CITY OF ALBUQUERQUE

**Re: Albuquerque Sign Print, 6010 Signal Ave NE, Certificate of Occupancy
Engineer's Stamp dated 8-22-04 (C18-D23)
Certification dated 4-27-05**

**Re: Albuquerque Sign Print, Signal Ave NE, Grading and Drainage Plan
Engineer's Stamp dated 8-02-04 (C18-D23)**

Sheet Title
GRADING/DRAINAGE PLAN
Drawn By: BLM/HTH Checked By:

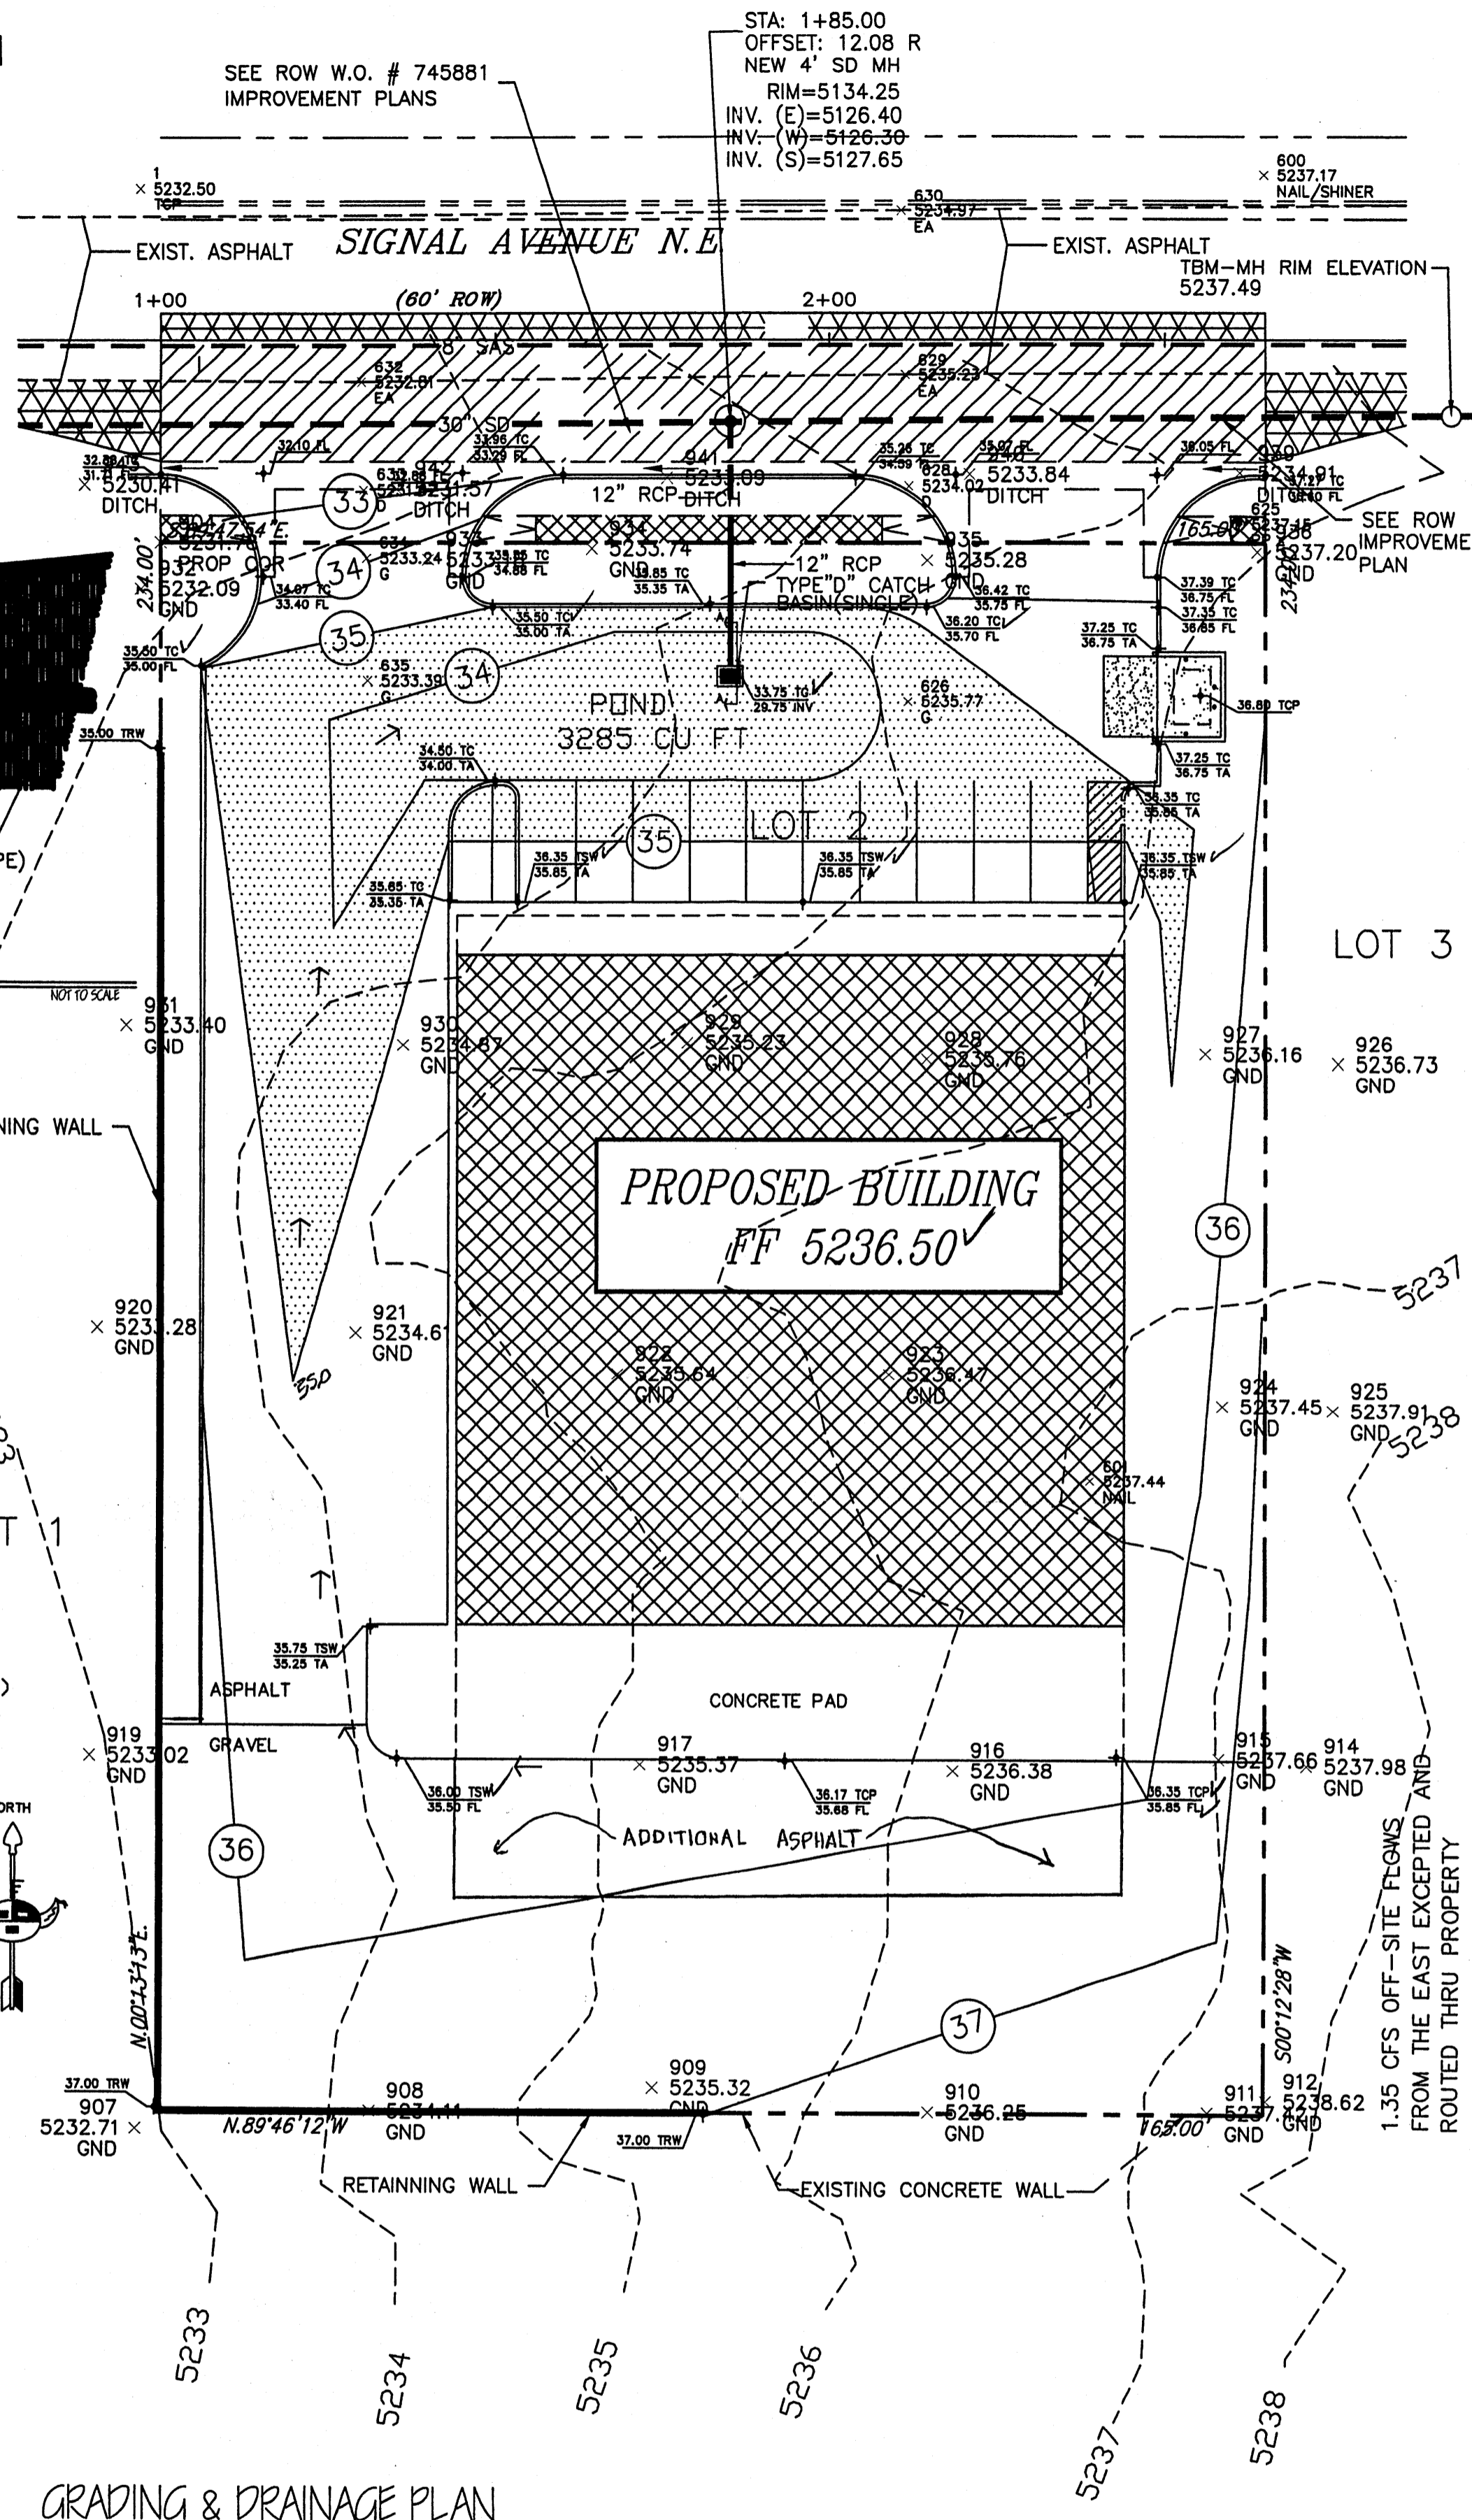
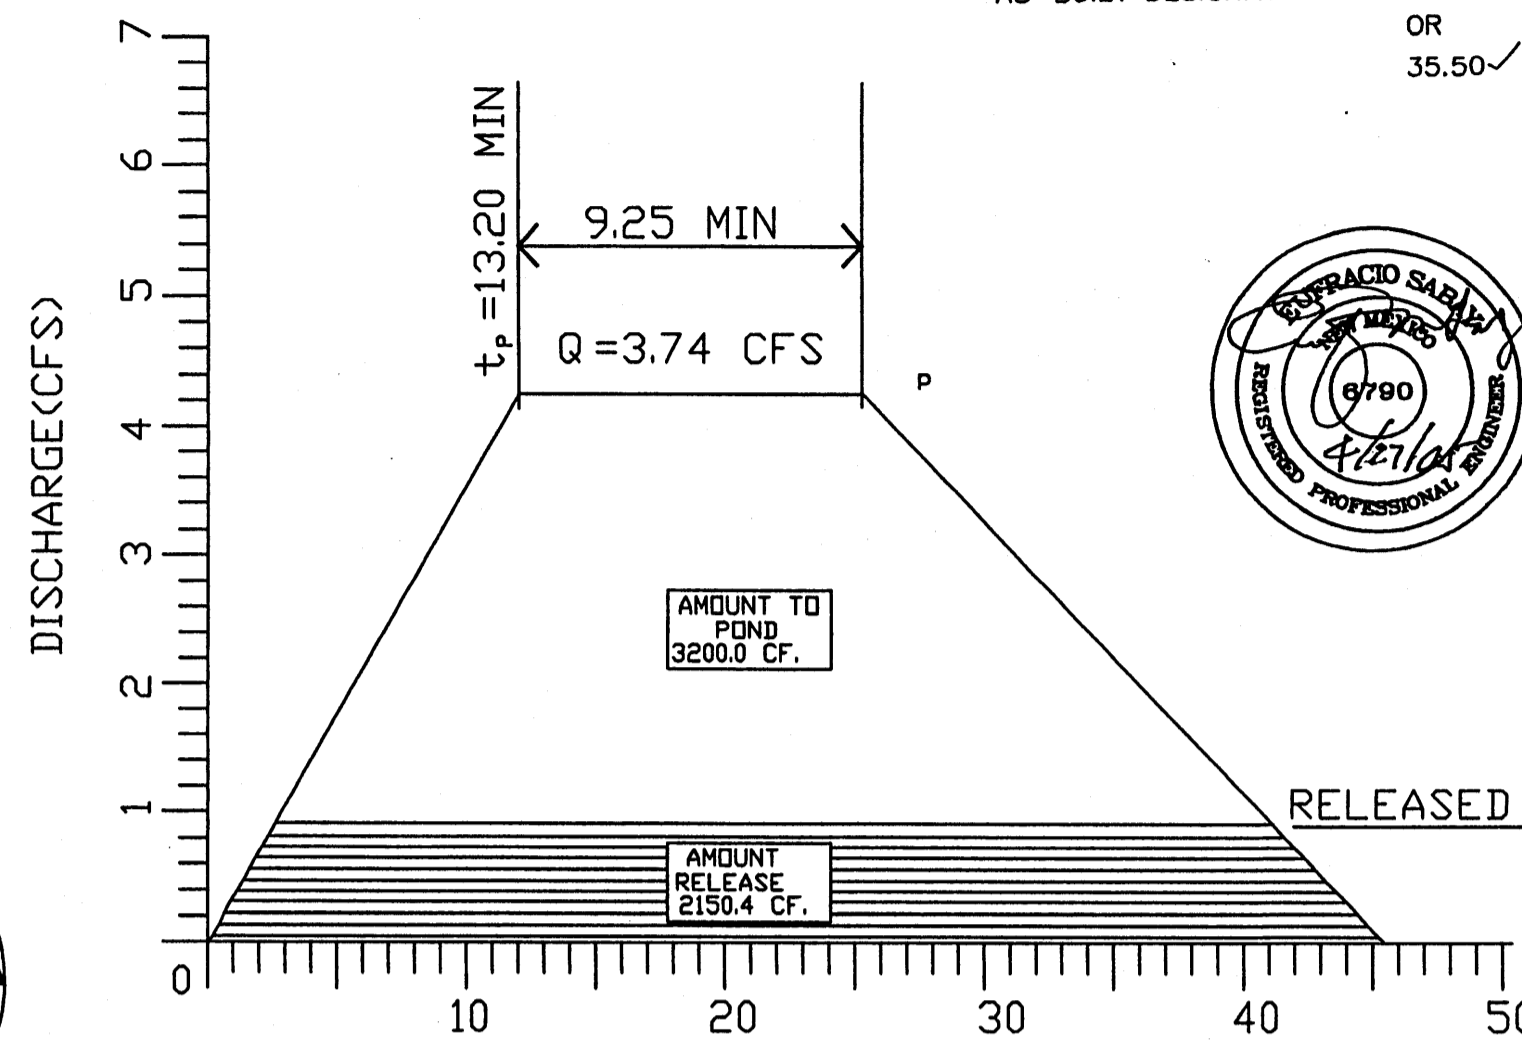
Based upon the information provided in your submittal received 8-03-04, the above referenced plan cannot be approved for Building Permit until the following comments are addressed:

1. The work outside the right of way must be built through the work order process. Therefore, a SO-19 permit is not needed.
2. Inverts must be provided for the proposed 12" RCP.
3. Please address offsite flows.
4. The orifice plate must be placed at the 12" RCP.
5. Define the extents of the existing ditch shown along Signal Avenue
6. Provide additional spot elevations within the southern half of the lot to demonstrate how the flow will reach the pond. Currently, the flow appears to pond along the sides of the building.
